September 25, 2018
MVEA Yoder Substation Subdivision Exemption – EX 18 001
Applicant Comment Response Letter

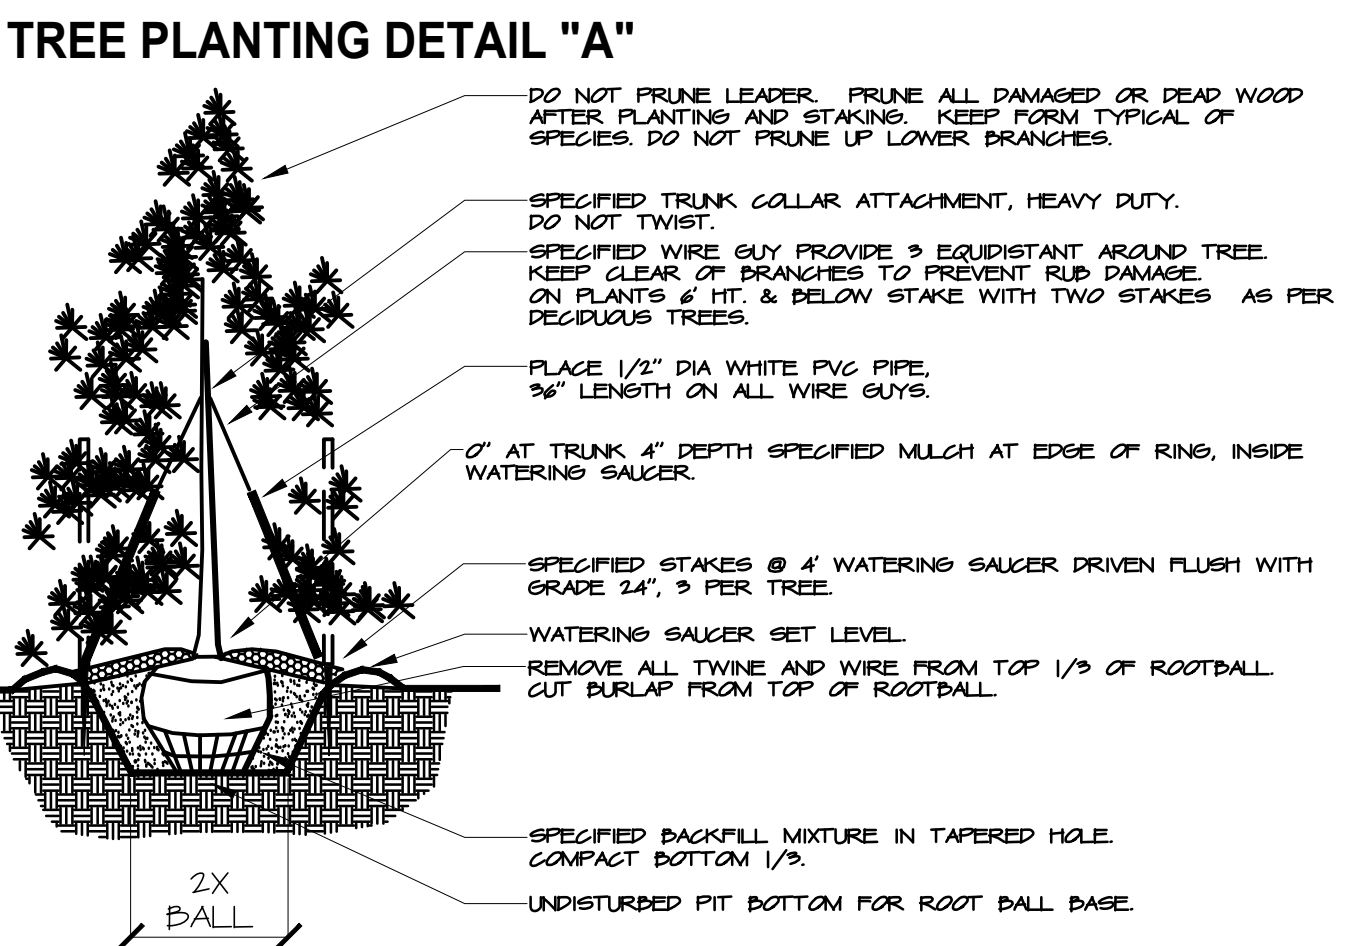
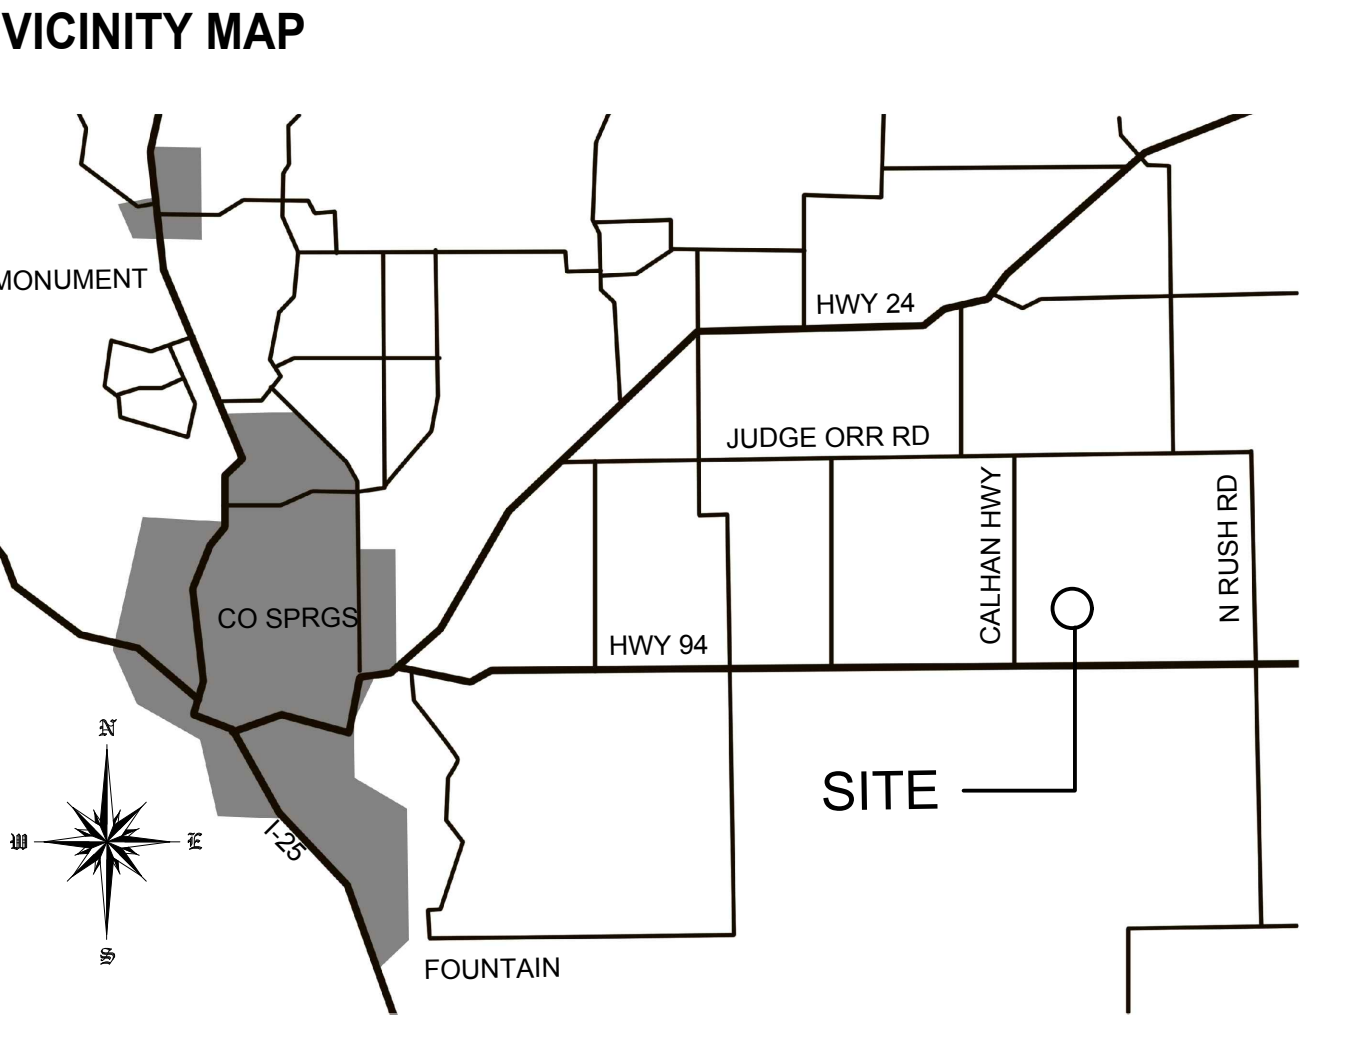
Landscaping Plan:
Added new detention basin design with proposed contours
